Disability Access Review

The Ribbon Hotel, Serviced
Apartments and Retail

31 Wheat Road, Sydney

Disability Access Review for DA Approval The Ribbon Hotel, Serviced Apartments and Retail – Darling Harbour

SCALE @ B1	DRAWN	CO-ORD	REVIEWED	APPROVED
1:300	RT	JO	JO	CW
PROJECT NUMBER	DRAWING NUMBER	REV		
A004409	ARC-HSL-DD-1060			F

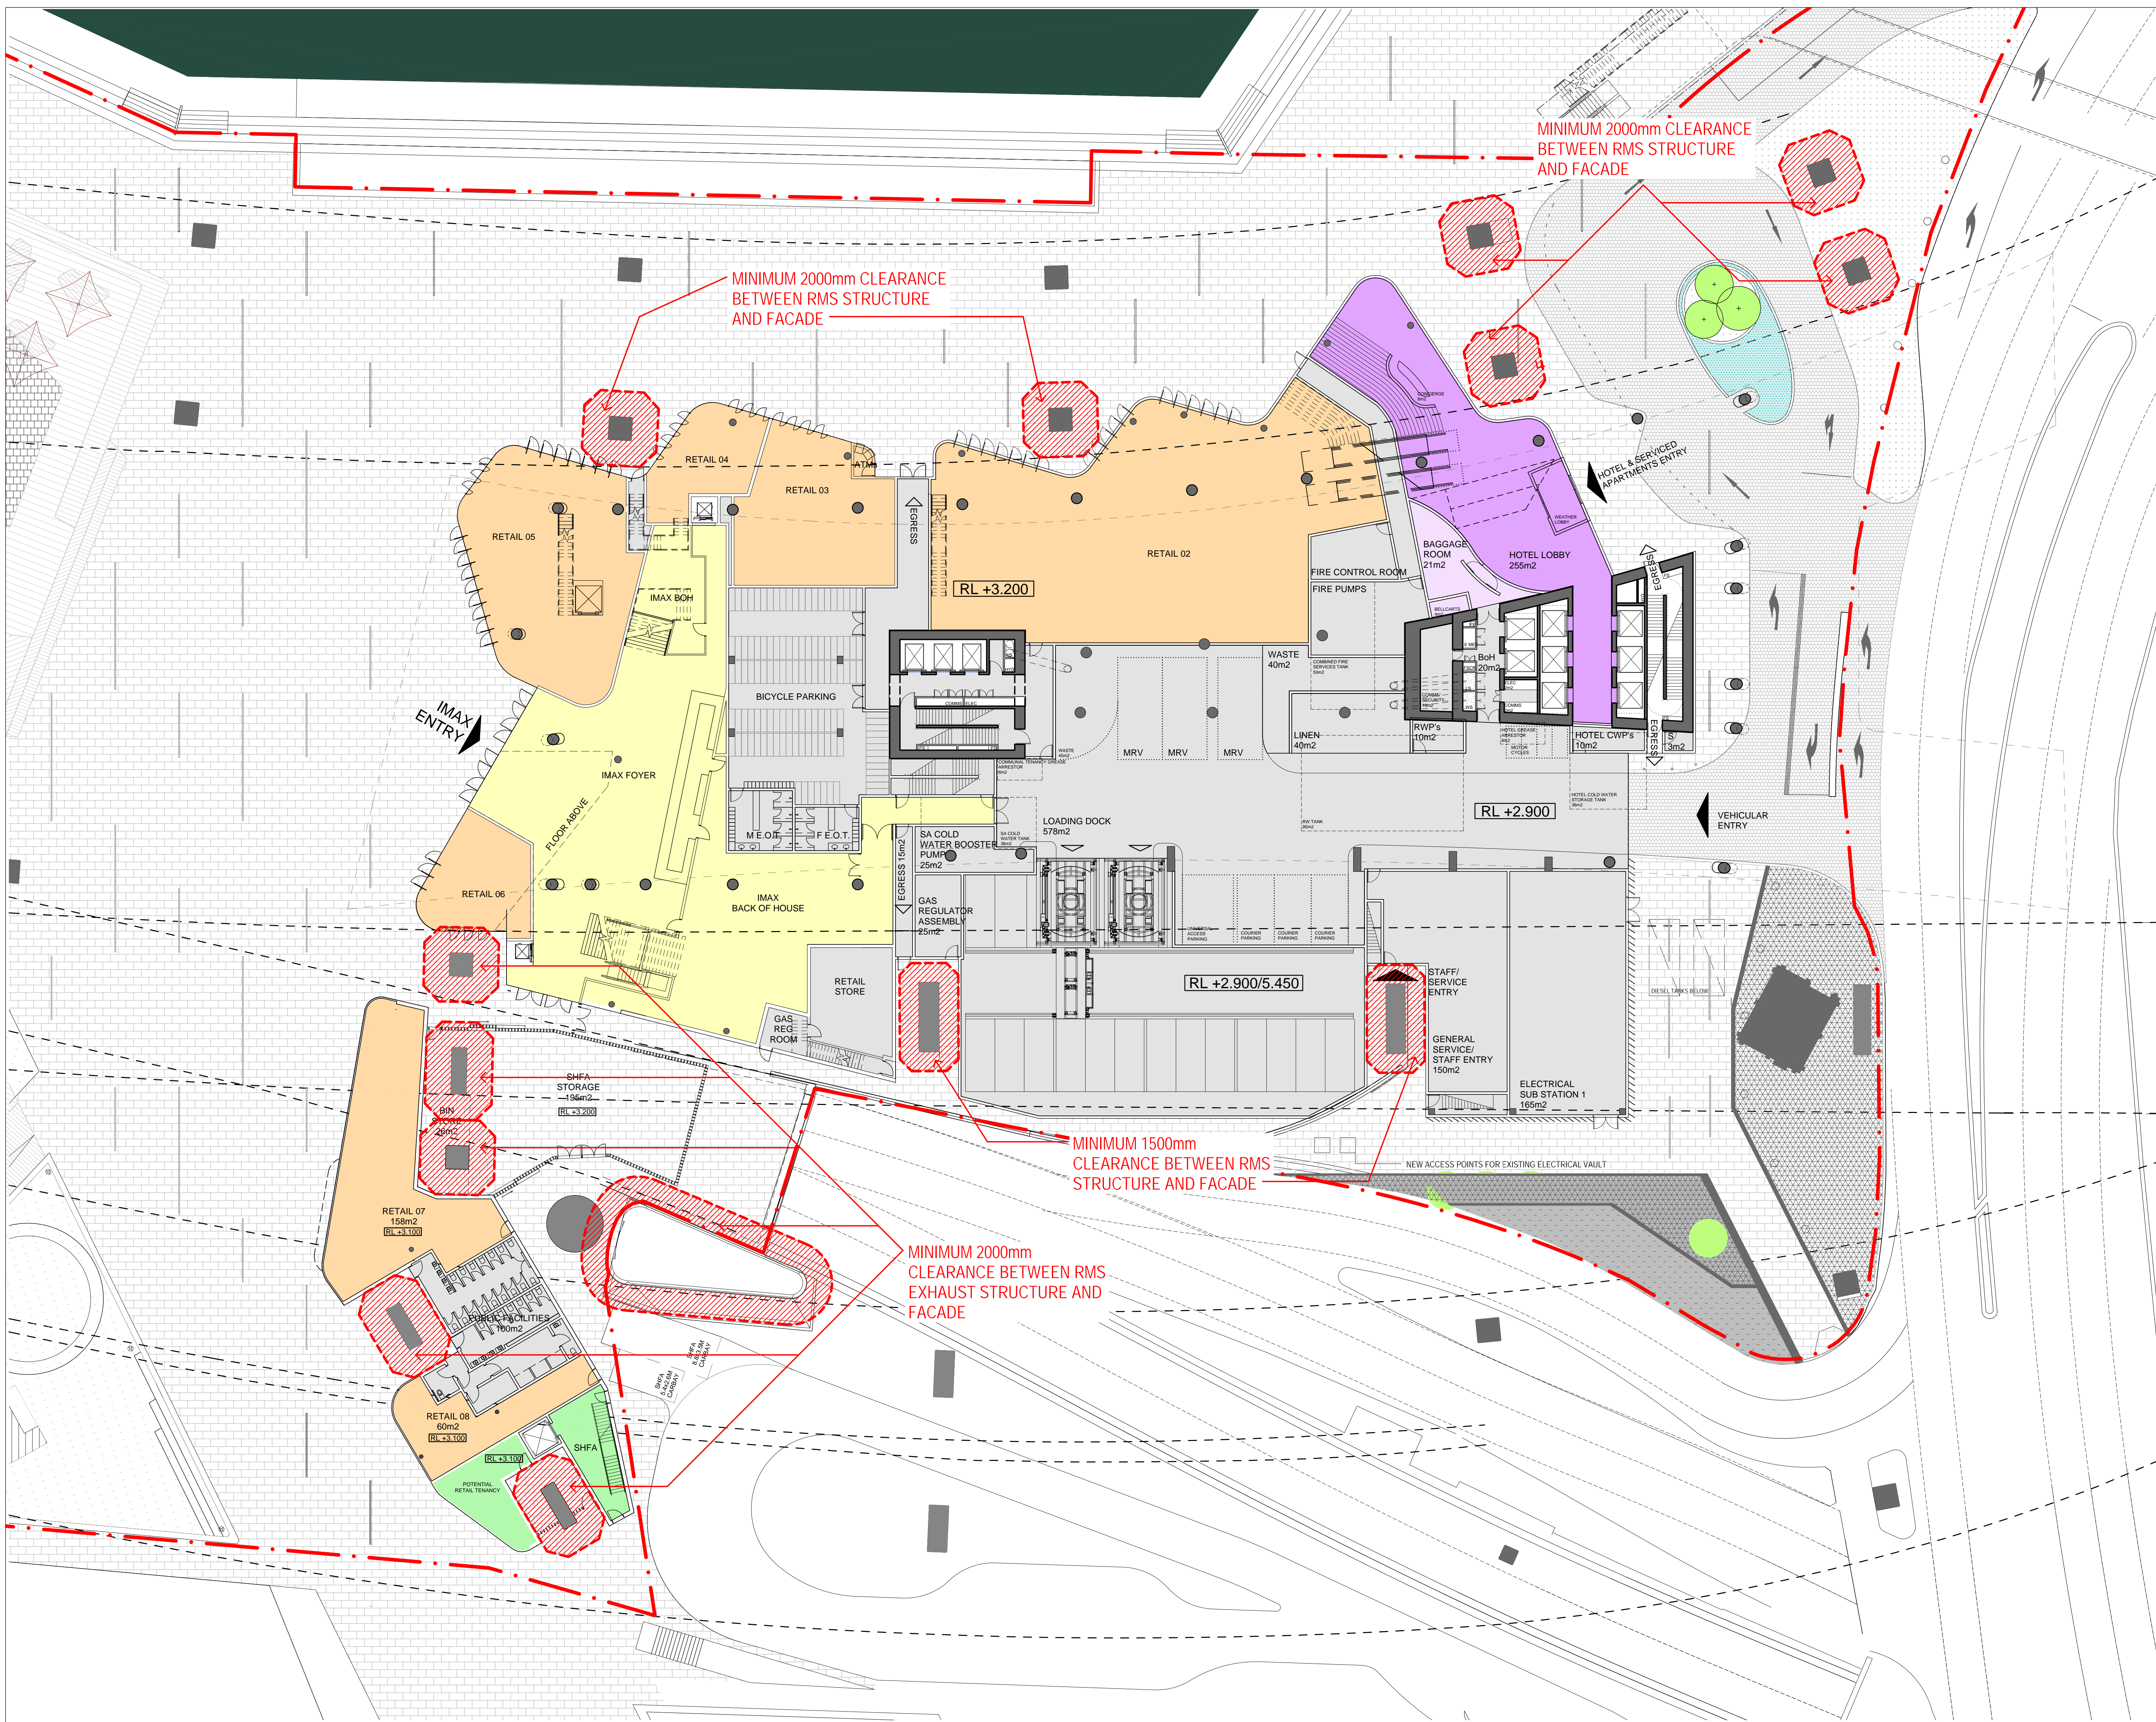
(b) identification of accessways at appropriate locations which are easy to find.			
Draft Lease Plan ARC-HSL-DD-1060			
ELEMENT	PREMISES STANDARD	POTENTIAL DDA ISSUE	RECOMMENDATION
All Public Domain Works Area	DP1	Approaching the retail and cinema from the surrounding area needs to be considered carefully in terms of wayfinding, paving, and barriers such as steps, terraces, lighting and other outdoor elements.	Attention to creation of effective, accessible wayfinding, including architectural, graphical, tactile features and audible communication will enhance the precinct as a 24 hour destination precinct that works with universal design principles. Provide green grass appropriate for toileting assistance animals. Use AS1428.1:2009 as a basis and augment with references found in the Australian

Human Rights Commission February 2013 Advisory Note on streetscape, public outdoor areas, fixtures, fittings and furniture.
Accessible drop-off/pick-up locations	DP1(a) (i)	People with disability require a dedicated access drop-off area near the building for drop-offs and pick-ups from taxis or private vehicles	The planned drop-off area adjacent the hotel lobby is the optimum place to locate a dedicated access drop-off zone as it will have surveillance and staff management at all times.
Ground Floor General Arrangement Plan ARC-HSL-DD-1070			
ELEMENT	PREMISES STANDARD	POTENTIAL DDA ISSUE	RECOMMENDATION
<i>S27 – E</i> Southeast corner vehicular entry by the Substation	D3.8 (1)(e) (ii)	The paved footpath crosses the vehicular entry to the parking station with a large angled wall and columns from upper levels at the driveway. The angle of the garden bed tends to send people out onto the roadway. Bollards are present on one side of the crossing but not the other.	For pedestrian safety, the accessway meeting the vehicular entry adjacent the building needs to be denoted by rows of warning tactile ground surface indicators (TGSIs) with 30% luminance contrast (or 45% if using discreet TGSIs) spanning the width of the accessway on both sides of the driveway as there is no standard kerb or kerb ramp. Also it is very important to highlight the access path itself with pavers that continue the pedestrian continuous accessible path of travel and to possibly re-shape the garden bed so that there is a straight alignment for crossing to the hotel entry. For TGSi configuration at vehicular entry, use AS1428.4.1:2009 Figure C12.

<i>S27 – E</i> Eastern external inclined columns in accessway	D3.8 (1)(e) (i)	Pedestrians with vision impairment or who are blind on the accessway east of the hotel entry must be warned about the two large inclined structural columns.	Consider options for shielding the inclined columns in the open public space with no clearly defined continuous accessible path of travel, such as creating raised garden beds around each column. Columns also need to have 30% contrast to the floor surface. A straight line also improves wayfinding for white cane users. The Premises Standard suggests that in absence of such a suitable barrier, TGSi are employed. Use AS1428.4.1:2009 Figure 2.6 (B).
<i>S27 & N19</i> Shared space for vehicles and pedestrians on Wheat Road	D3.8 (1)(e) (ii)	As a shared space, bollards will delineate the vehicle and pedestrian areas along a flat kerb. Some white cane users may miss this signal. There are also different paving materials for pedestrians and vehicles but no indication if they contrast texturally with each other. It would appropriate	There is some debate as to whether TGSi are mandatory for the length of the drop-off road on the east of the building. It is a shared space parallel with the pedestrian accessway, not crossing it. Currently bollards are the only wayfinding device. Best practice is to use a 600mm deep TGSi band as in AS1428.4.1 Figure 2.5(A) to define the pedestrian way from a carriageway at the same grade for maximum protection of pedestrians.

to provide more ground-based textural and contrast safety information even in this low-speed environment.	If TGSIs are not used, a similar width band of 30% contrasting colour with highly textured pavers to create a contrasting horizontal shoreline is highly recommended set behind the bollards along the length of the bollard array. Information in Draft AS1428.4.1_2015 Figure 2.3.
<i>E5</i> Hotel Entry	D3.2 (2)(a)	Hotel entry is via sets of automatic doors between a large weather lobby airlock. This is best practice in universal entry, especially as many guests will come with luggage.	The Hotel entry needs to be clearly visible from side and front approaches and framing to include 30% luminance contrast frames to surrounding material. See AS1428.1 Clause 13.1. Adjacent glass and the automatic doors itself will require glazing strips as in AS1428.1 Clause 6.6 and frame contrast as in Clause 13.1. The airlock matting must be fully compressed and level. See AS1428.1 Clause 7.4.2.

<i>E1-E4</i> Hotel lobby	D3.8 (a) and (b)	The hotel lobby hosts a very wide feature staircase, escalators and six lifts to access upper levels. They are spread across the lobby span but all conveniently located in the large space.	Compliant features all well located. Ensure staircase has appropriate handrails and both staircase and escalators have compliant warning TGSIs with information directories and signage easily located.
<i>N16-E1</i> Concierge desk position and design	Draft AS1428.4.2 Clause 2.7 (c)	point of contact will be a 24 hour manned concierge desk with the function of practically assisting all guests, particularly those with vision impairment or blindness.	The desk itself should have accessible heights recommended in AS1428.2 Clause 24 and hearing augmentation facilities. See AS1428.5. Information directories and clear large pictogram signage will also be important for independent navigating to escalators and lifts.

<i>N13-N1</i> Retail tenancy door openings	AS1428.1-2009	Banks of outward opening single doors are shown as the openings for each retail tenancy. Outward opening doors can create problems of detection and of hazard for blind and vision-impaired people using the wall as a shoreline. Opening the walls portals with stacking doors may be a safer option than a series of distinct single doors.	Review door opening design in terms of visibility and safety. Ensure all doors comply with AS1428.1 with glazing strips as in Clause 6.6 and 30% luminance contrasting door frames as in Clause 13.1. All doors must also meet the 850mm clear width opening.
<i>N13-N1</i> Columns in tenancies	D3.8 (1)(e) (i)	Several tenancies have the inclined column going up through its floor plate. Issues of vertical clearance to 2m need resolving.	All columns need to be contrasted 30% to their surrounding floor surface to increase visibility. Where other fitout solutions are not employed, use TGSIs to denote the 2m vertical hazard shown in AS1428.4.1:2009 Figure 2.6 (B).

N7 – N8 Retail tenancy 02	DP1 (a) (iii)	Current plan does not show either stairs or lift access to upper mezzanines of Tenancy 02. This does not meet Premises Standard requirements to provide access to work and public spaces in new buildings.	Provide stairs and lift alternative to each separate tenancy with a mezzanine storey.
N13-N1 Retail/food tenancies to west and north	Best practice	Currently some delineation or blades are proposed on the retail building facade which break up the solid wall of the podium level. A solid building line is easier for white cane users than one broken with blades or fins jutting out, assisting them to shoreline safely around the perimeter.	Be aware of City of Sydney by-laws for placement of tables and chairs away from building edge to provide clearance for white cane users to detect the edge for shore-lining. If blades remain as wall features as well as doors that swing outwards, create a 3m wayfinding path with a textural surface around the retail tenancies with contrasting and textured paving materials to highlight the safe pedestrian accessway between outdoor furniture and the building edge. Refer to Draft AS1428.4.2 Clause 2.6.

Southwest corner separate tenancies with amenities	CPTED principles	Potential for entrapment exists for sanitary facilities entry corridor behind the exhaust structures which blocks views of people entering and exiting and gives a hiding structure.	Consider more direct access to all toilet and parent room facilities on the exterior faces to ensure safety and visibility in activated spaces, away from internal column supports. Ensure premium access levels to these toilet and first aid facilities at the south end of Darling Harbor.
Western entry and emergency exit doors to IMAX foyer	D3.2 (2)(a)	Entry is via four sets of double doors all opening outwards with four additional single leaf doors as emergency exits and departure doors. All door leafs meet minimum requirements to provide an 850mm clear width per leaf.	In terms of best practice, consider automating one or more of these IMAX entry doors to improve access or changing them to become automatic sliding door openings to assist people with many types of impairments have easier entry to the IMAX.

IMAX entry	D3.3	IMAX entry to Level 01 and exit from Level 01 is via lifts, escalators and stairs all co-located to provide equity for ambulant and non-ambulant customers.	Ensure stairway meets AS1428.1 Clause 11 and stairs and escalators have compliant warning TGSi.
